# CITY OF ALBUQUERQUE

December 5, 2011

**Re: Lindo Mexico Restaurant, 7209 Central Ave. NE, Traffic Circulation Layout  
Architect's Stamp dated 10-21-11 (K-19/D144)**

FILE # 1130CSITE
23 AUG 11

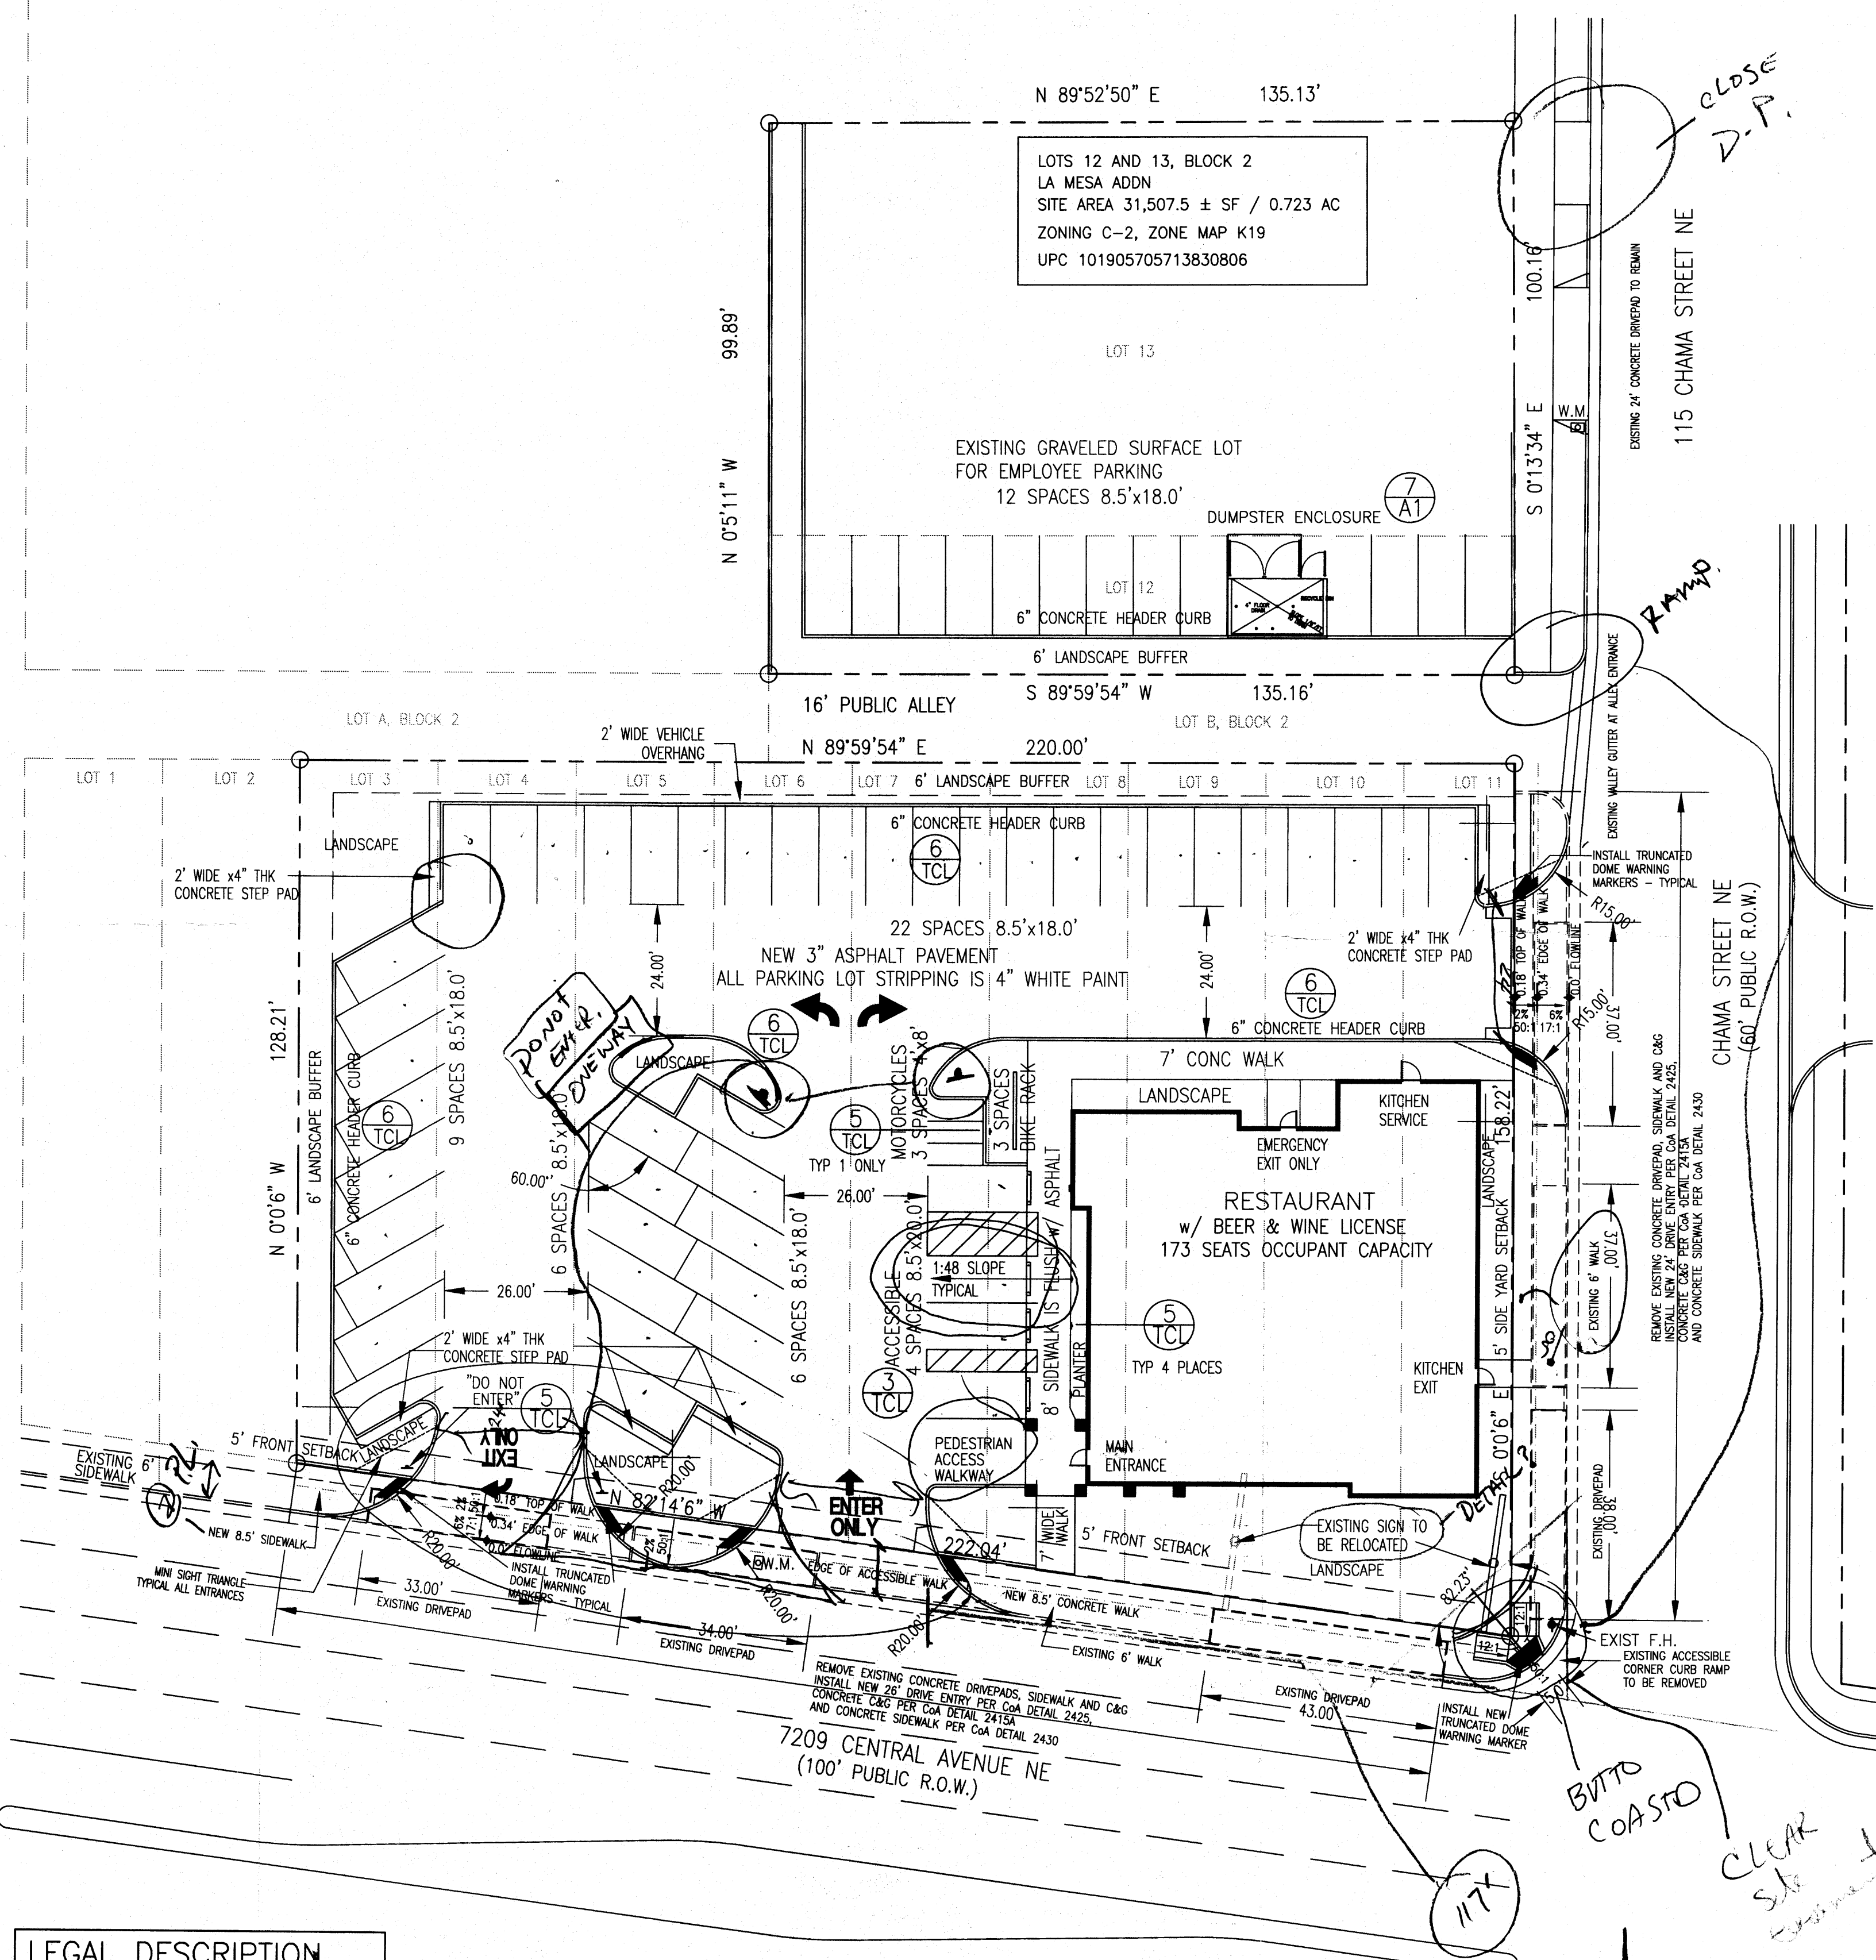
1. Please clarify the status of the proposed platting action. What is the DRB project number? An approved preliminary plat must be provided prior to building permit approval.
2. Please show the revised lots lines per the proposed platting action.
3. It has been noted that existing conditions restrict the ramp at the corner of Central and Chama Street. Please clarify what conditions restrict this redesign. If the existing property lines are the restriction, this will be modified by the replat.
